Acceptance of Applications Checklist

Tillbridge Solar Project Section 55 Acceptance of Applications Checklist

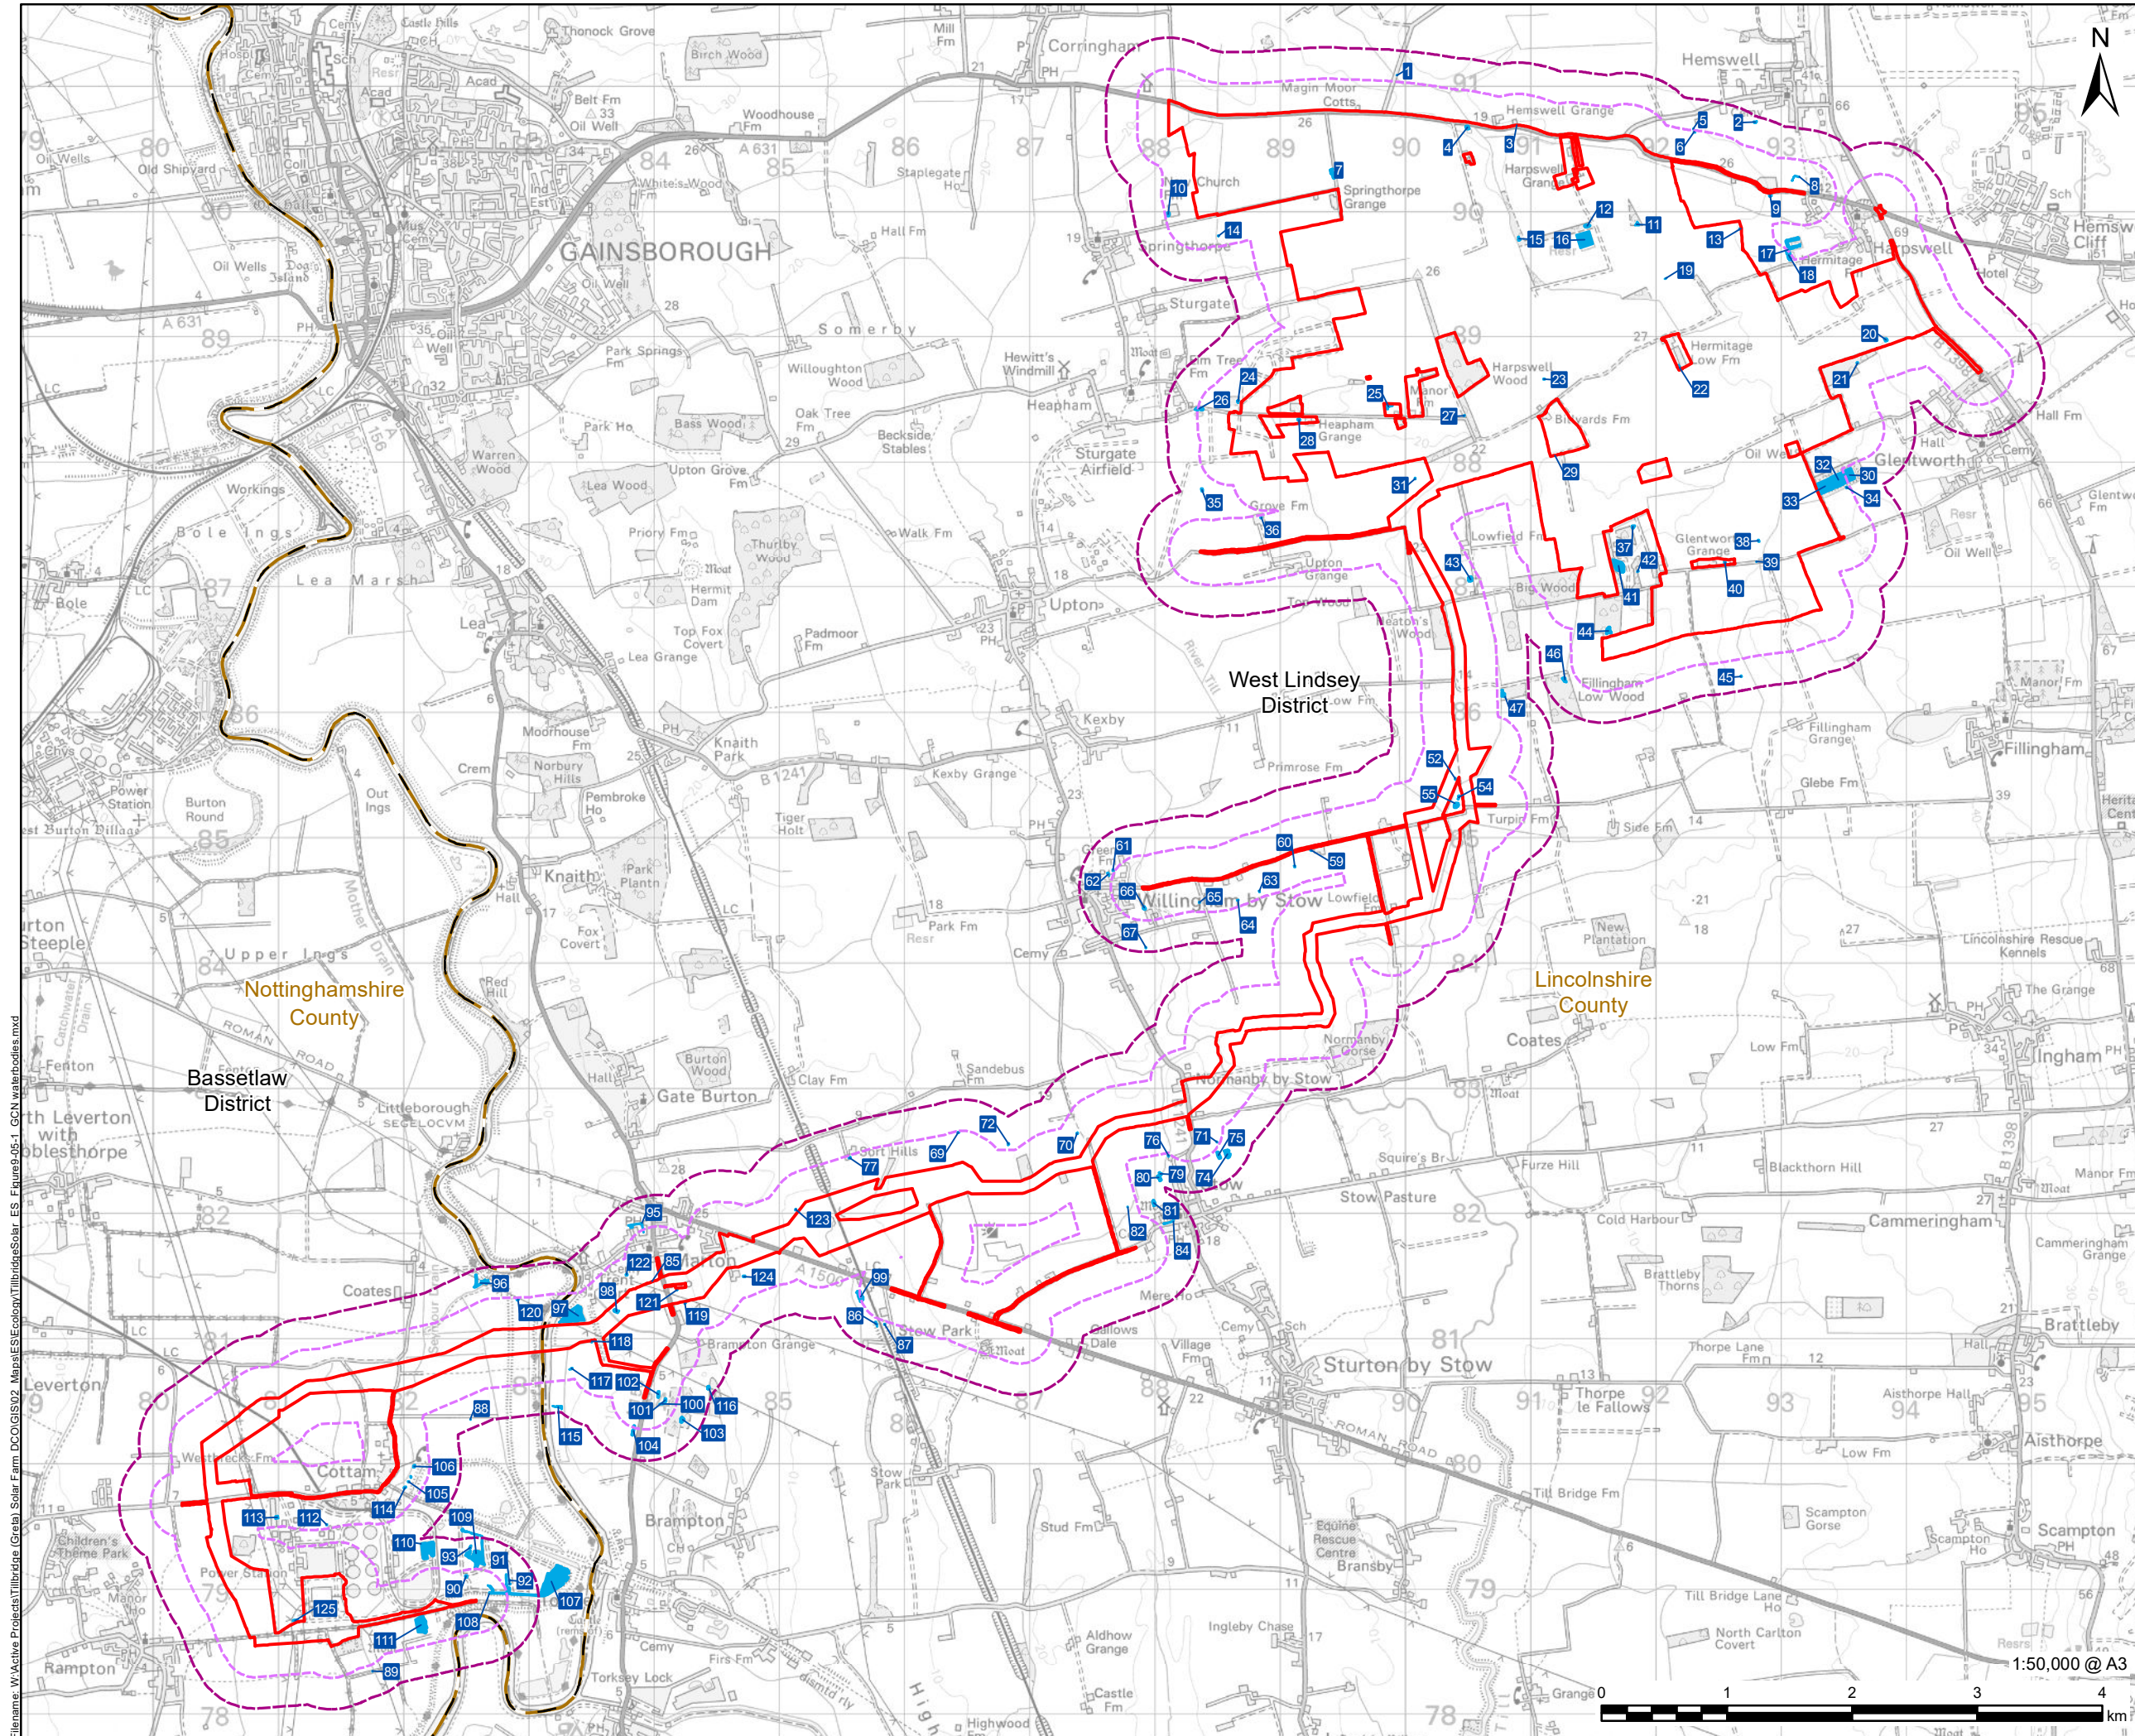
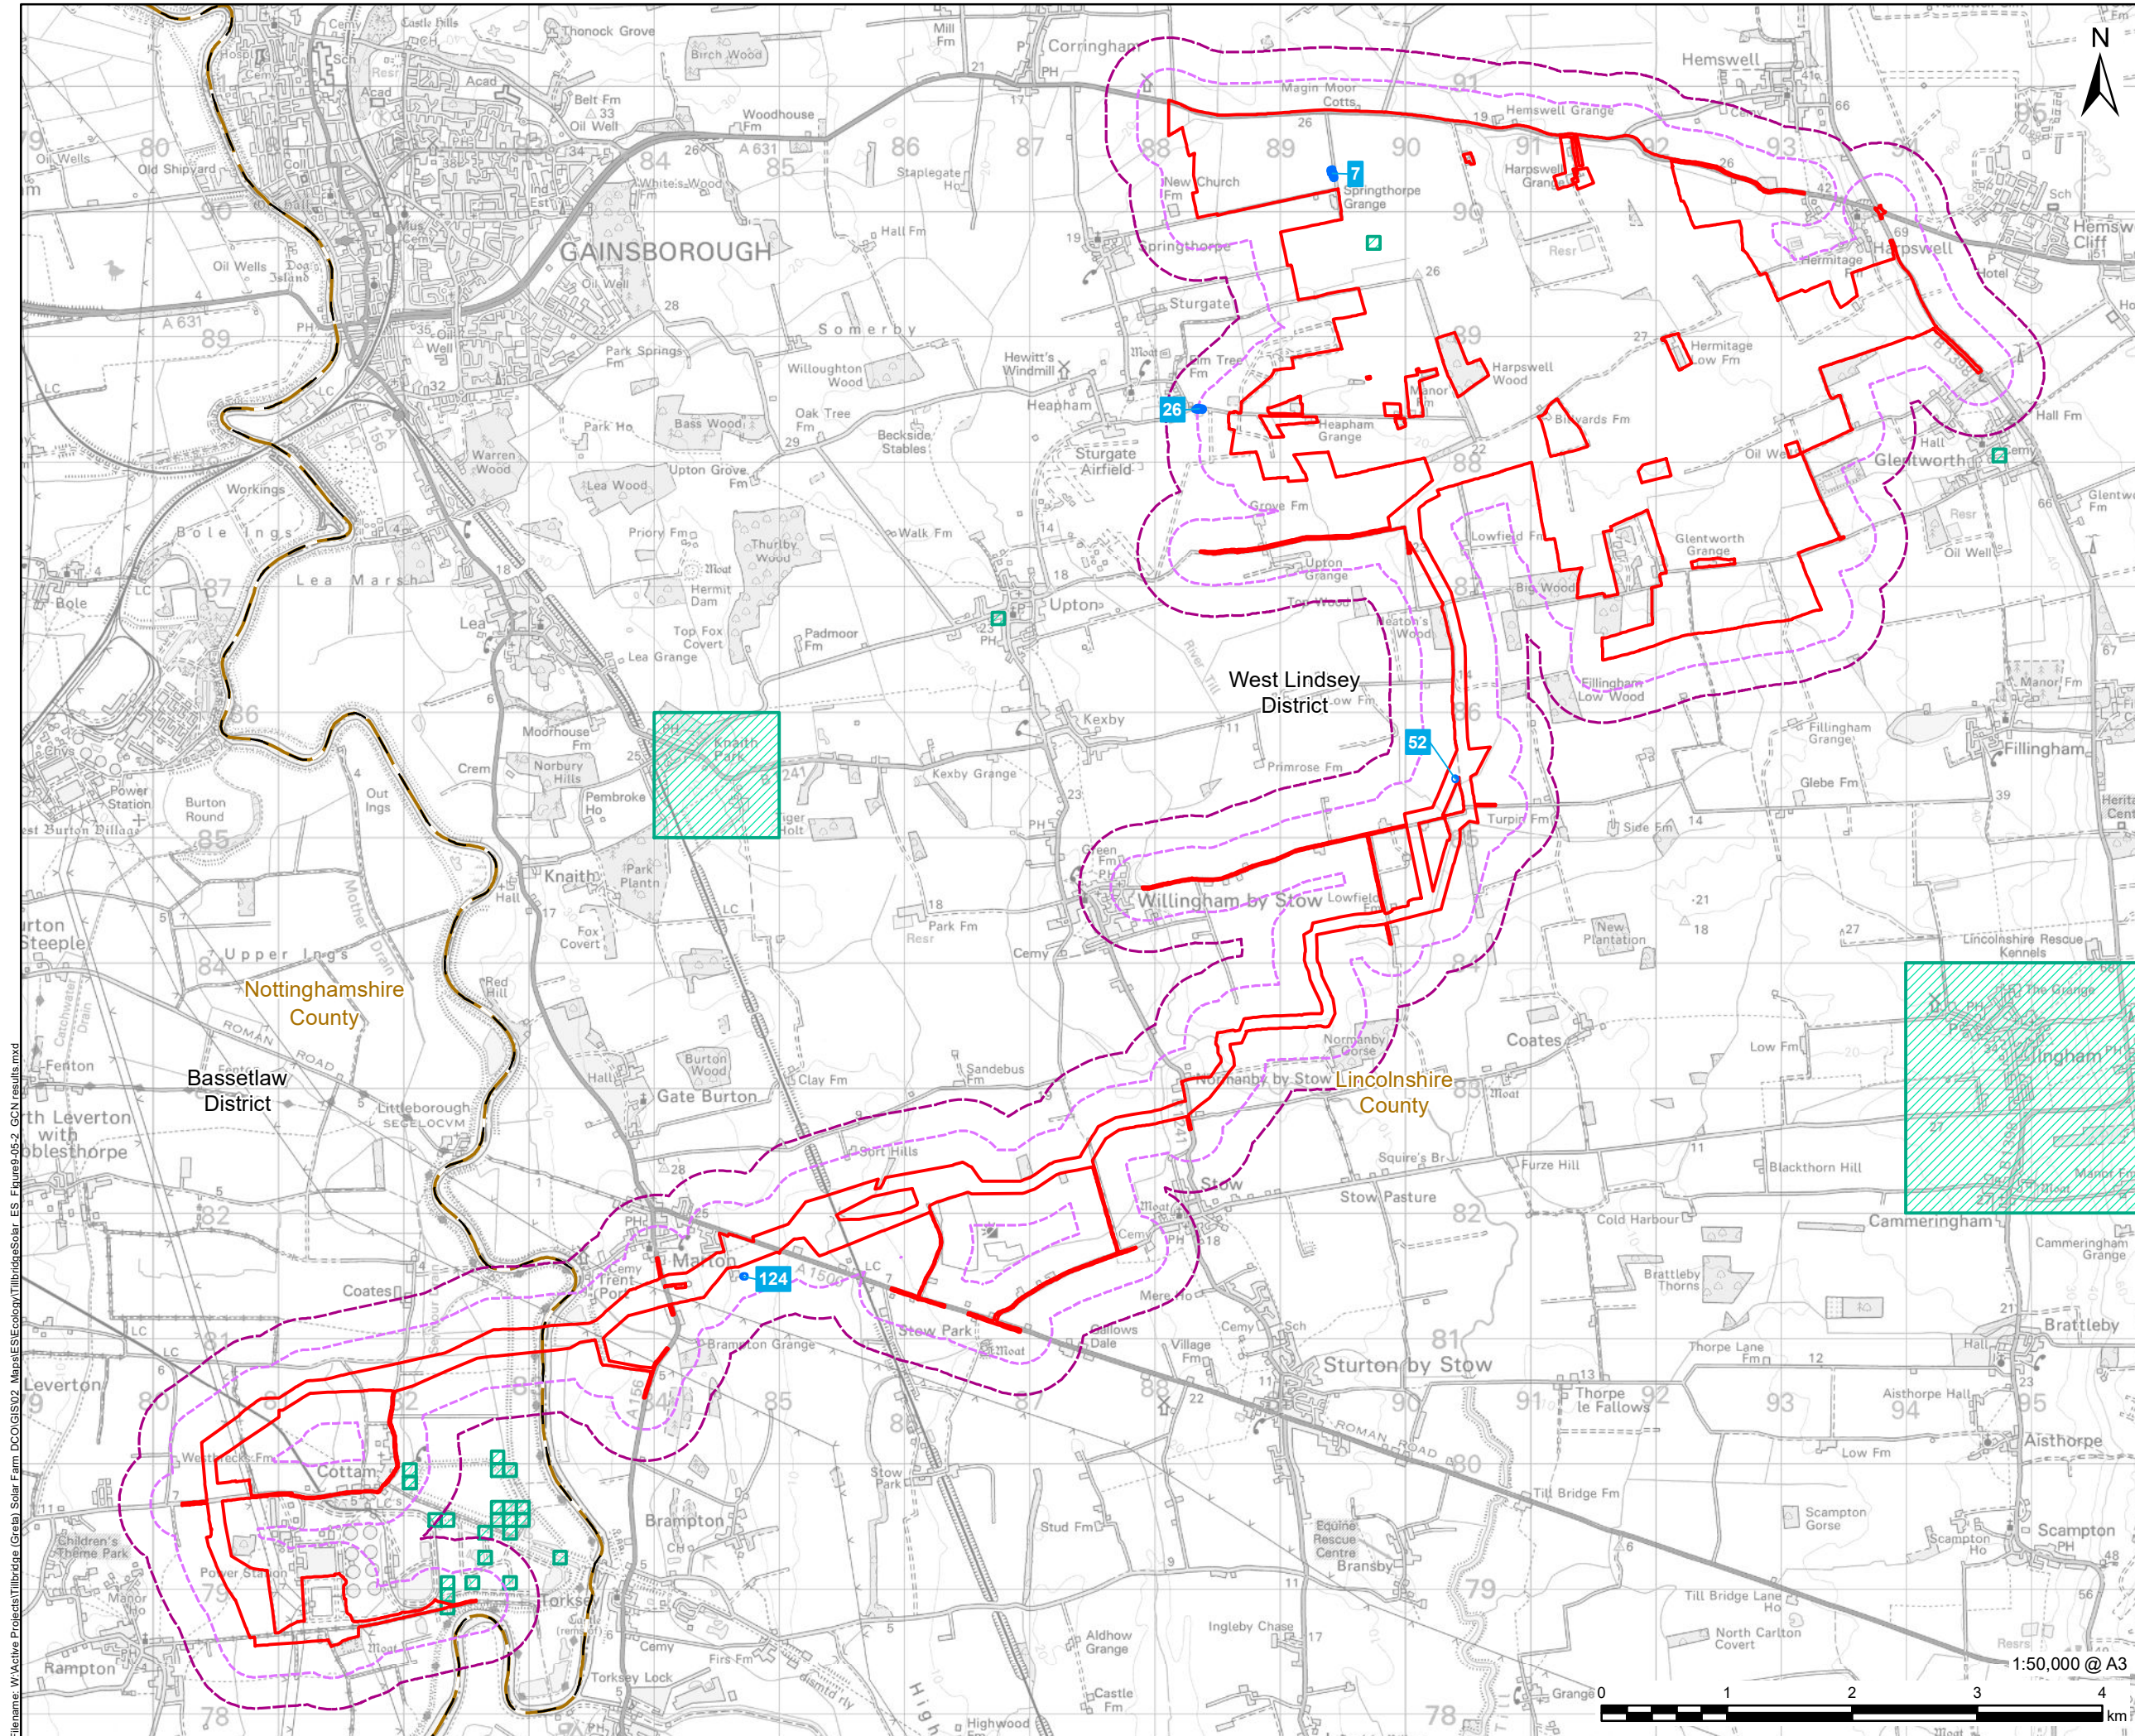
ES Appendix 9-5 (Doc 6.2) redacts field numbers.

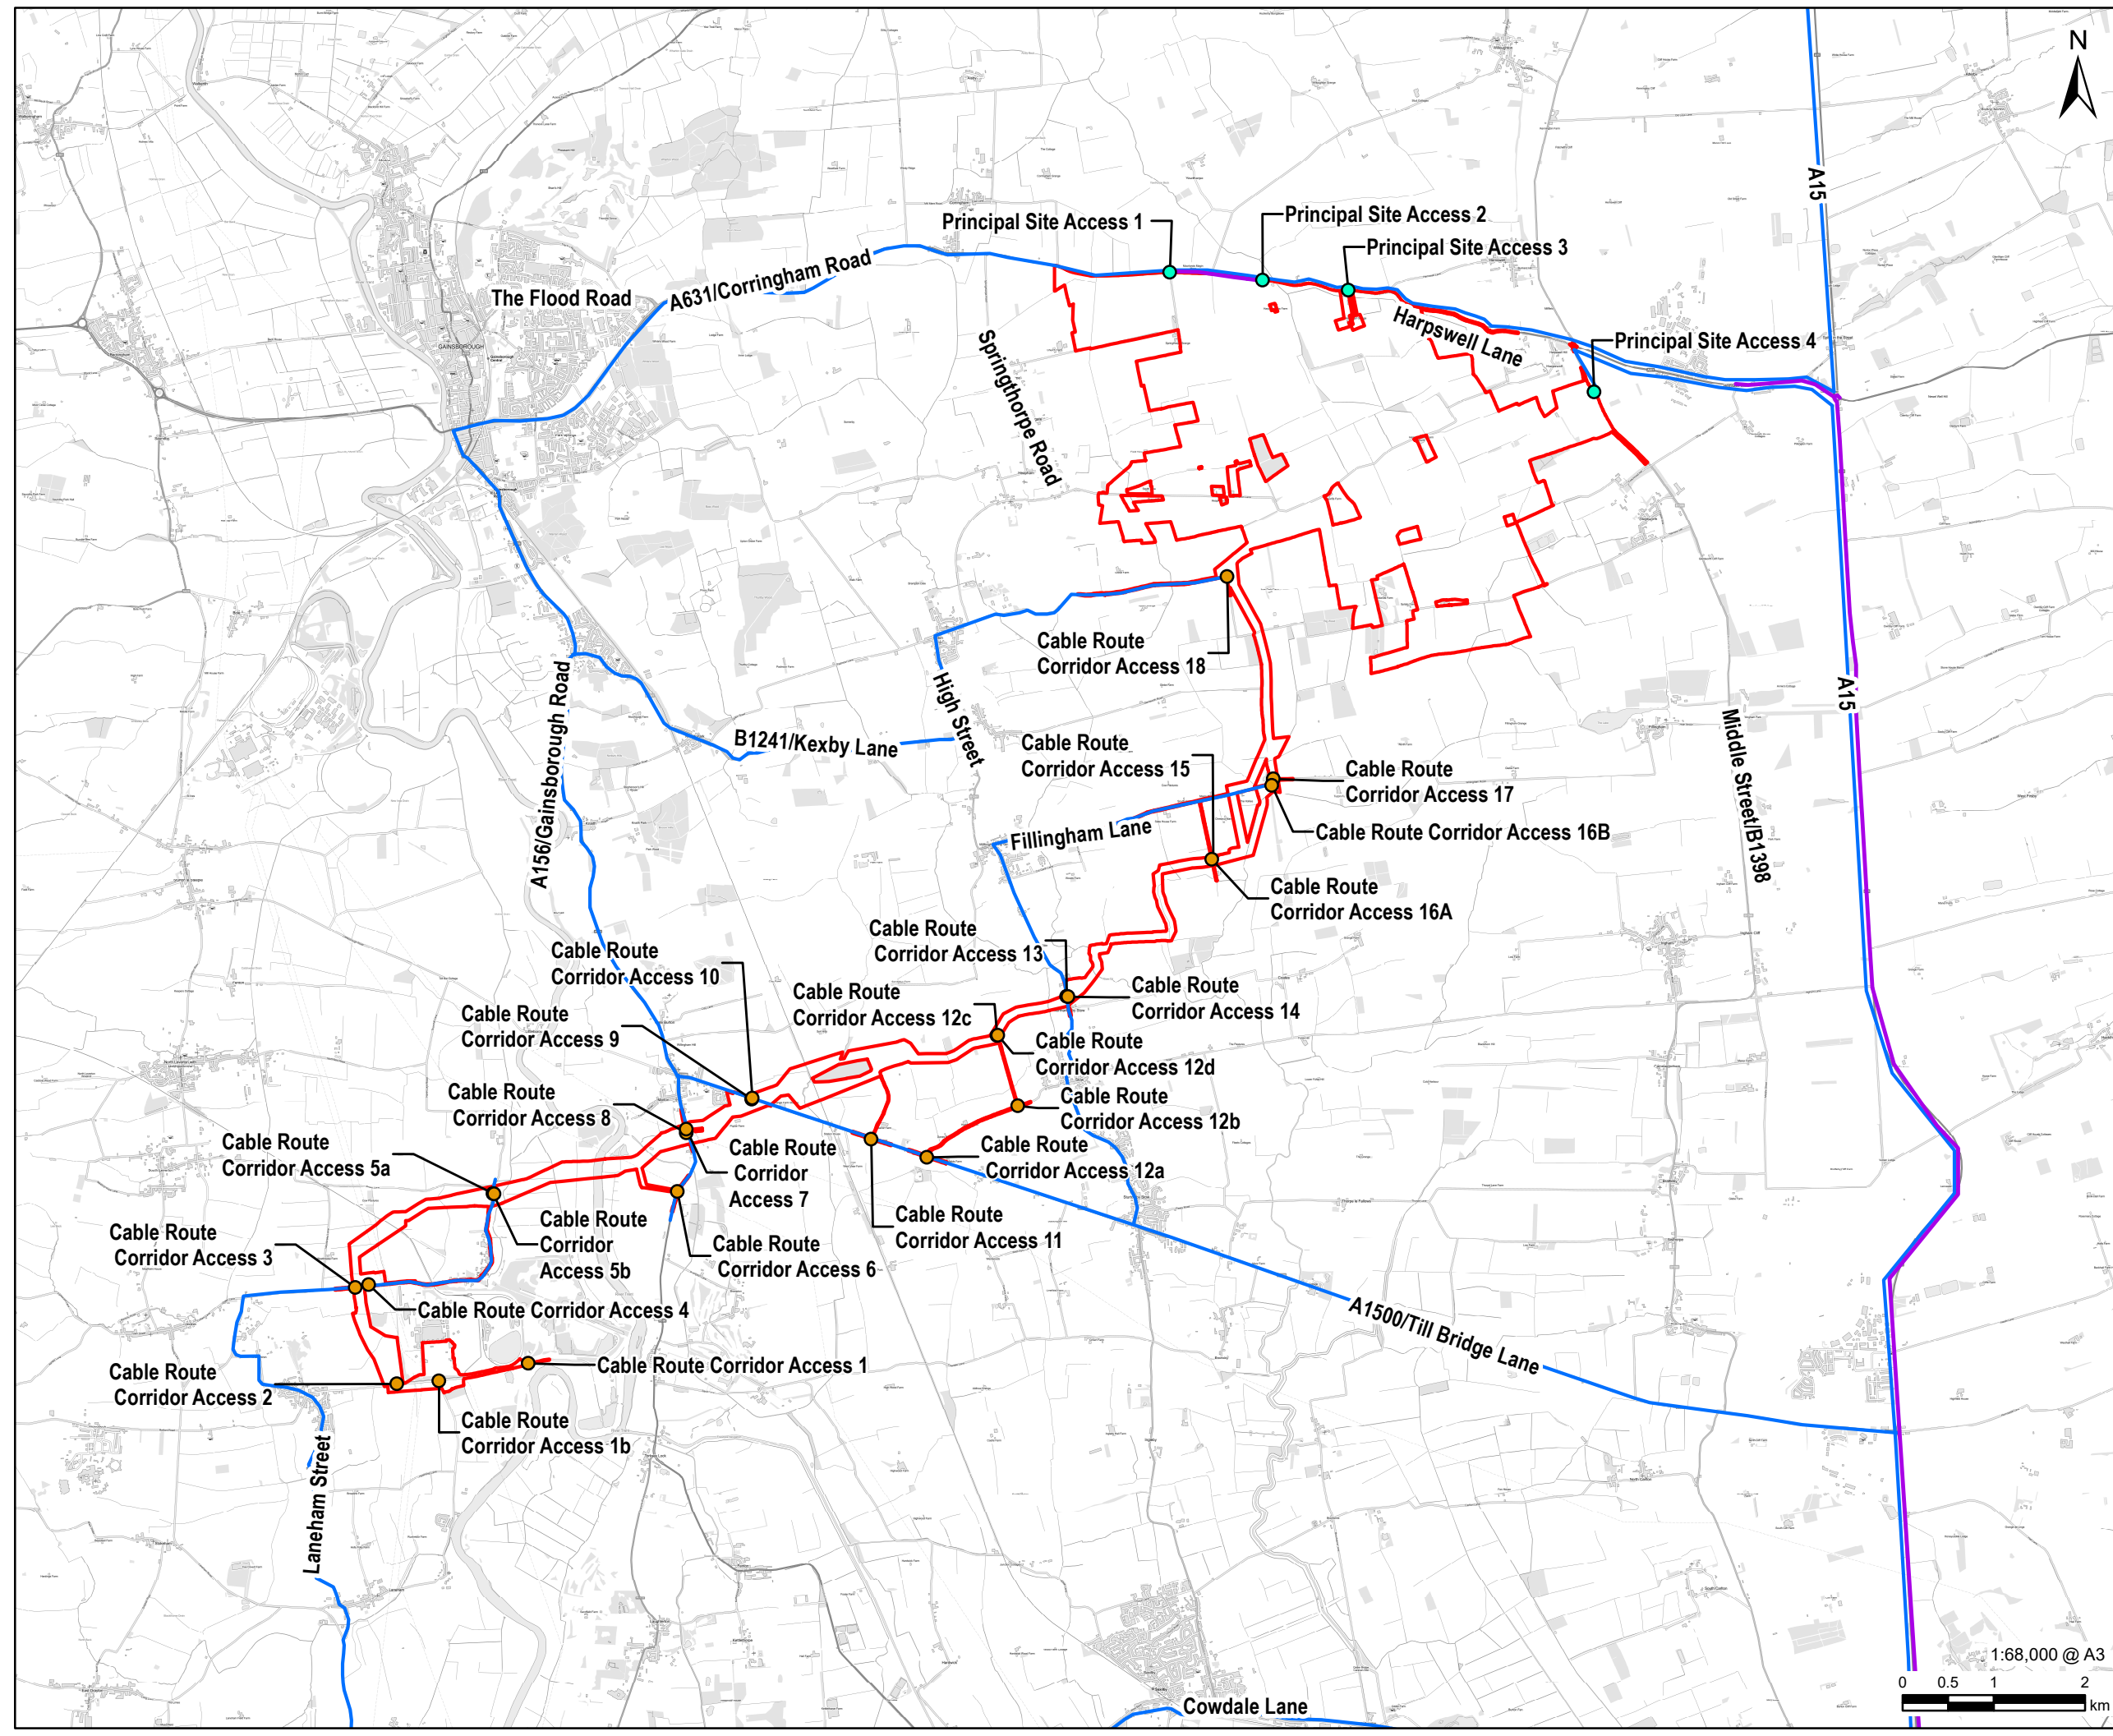
ES Figures 16-3 and 16-8 (Doc 6.3) are missing road names / numbers.
